CITY OF ALBUQUERQUE

June 13, 2017

RE: **Sonic @ 8th and Bridge
Drainage and Grading Plan
Engineer's Stamp Date 6/5/17
Hydrology File: L14D025A**

DRAINAGE AND GRADING PLAN

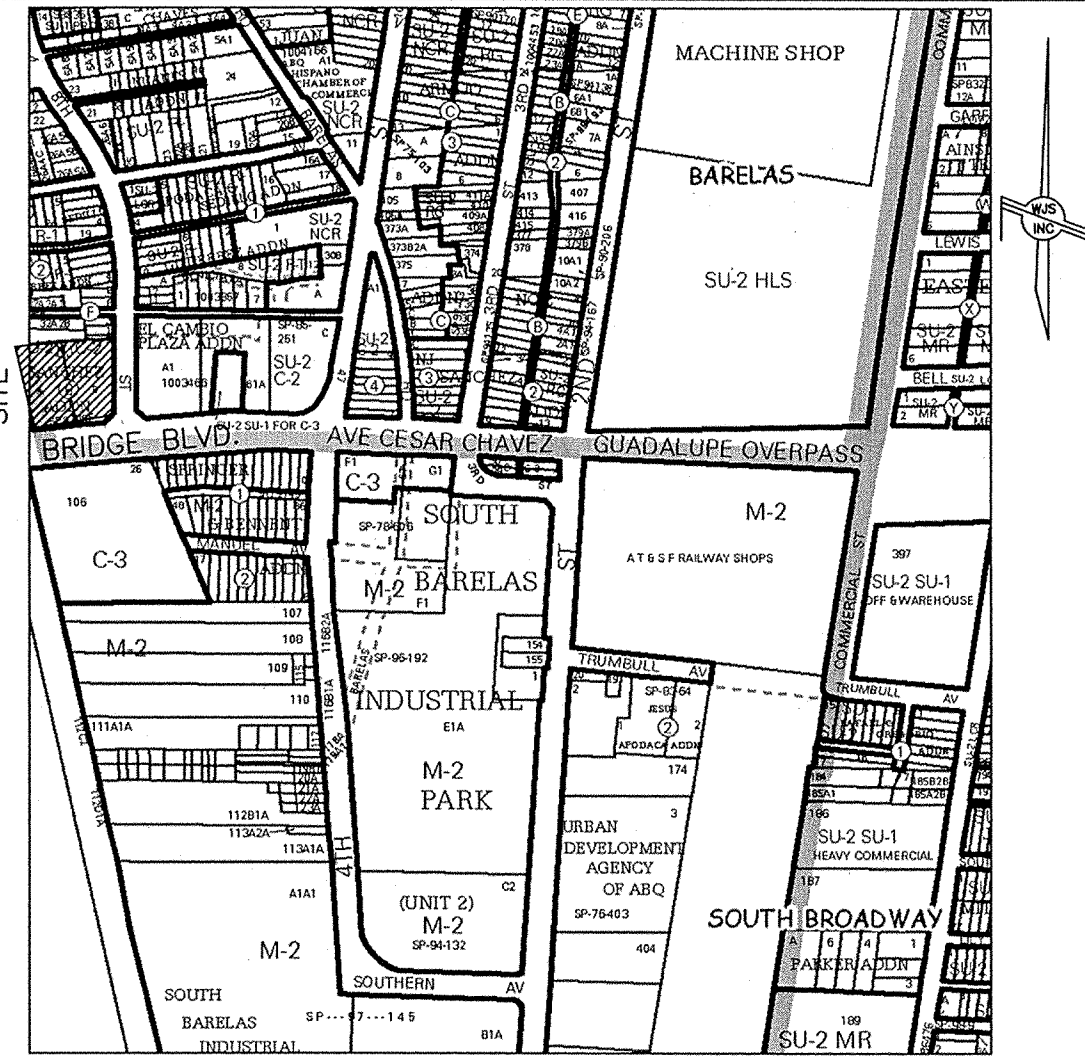
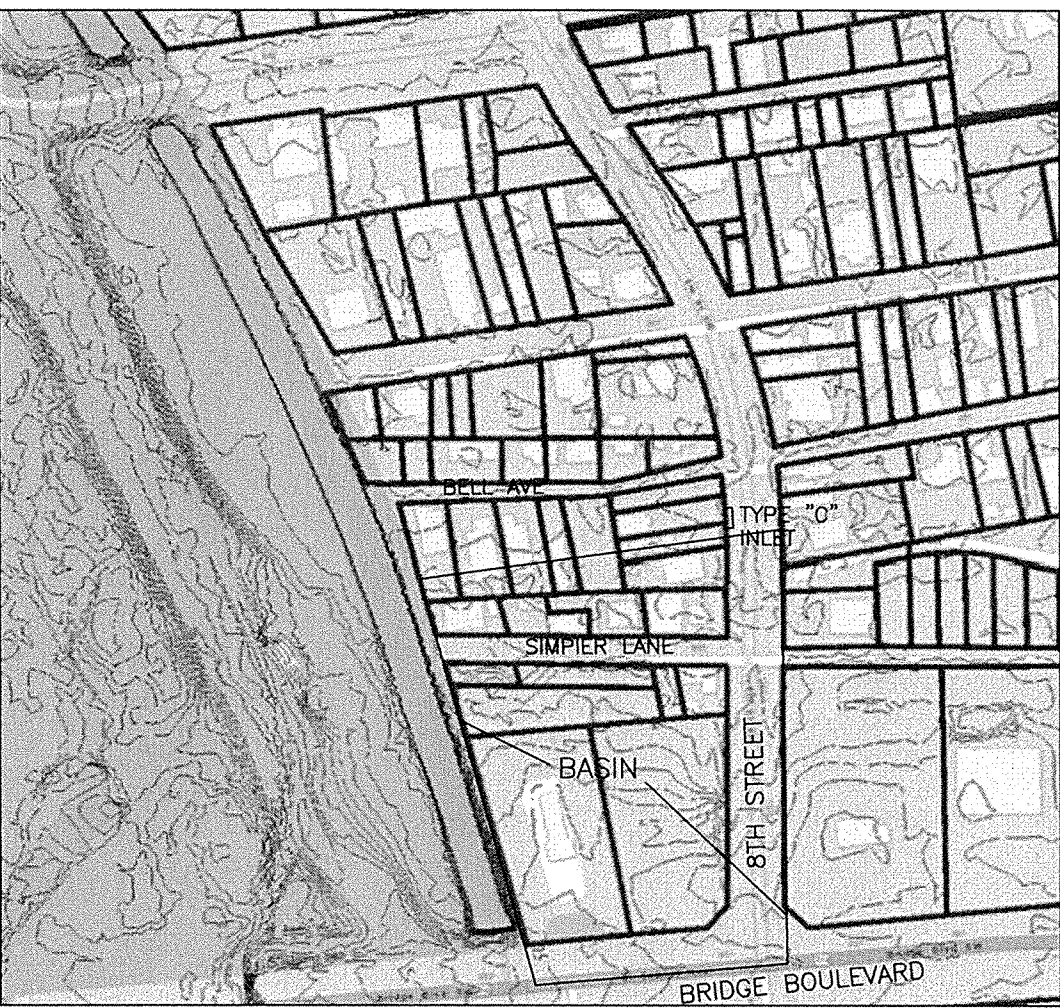
1. The site must demonstrate adequate downstream capacity per § 14-5-2-12 (10)(G) of the Albuquerque Code of Ordinances.
2. The drainage plan and narrative description must provide an offsite drainage basin map showing all areas that drain through and around the site to a reasonable analysis point that demonstrates downstream capacity.

3. Provide more detail on the proposed grades. Specifically, the proposed contours appear to ignore the curb heights and several of the spot elevations.

4. The alley section needs to transition to a cross-slope sooner in order to route flows into the pond.
5. Provide additional details for the Rip-Rap rundowns: size, thickness, dimensions, flowlines, flow capacity, invert elevations, etc.

6. Provide waterblocks, at least 0.67' high, at the entrances off Bridge to prevent flows from entering your site from Bridge.
7. Provide an existing conditions sheet (or Demo sheet) showing facilities to remain and those to be removed.

8. The dumpster area will need to be contained drained through a grease trap, and into the sanitary sewer.
 9. Include all items in the legend.
 10. This site will require an ESC Plan to be submitted to the Stormwater Quality Engineer (Curtis Cherne, PE ccherne@cabq.gov) prior to Building Permit approval.
 11. Standard SO-19 notes need to be included on the plan.
 12. A cross lot drainage easement is required between Lots A and B.
 13. A private facility drainage covenant is required for the pond
- If you have any questions, please contact me at 924-3695 or dpeterson@cabq.gov.
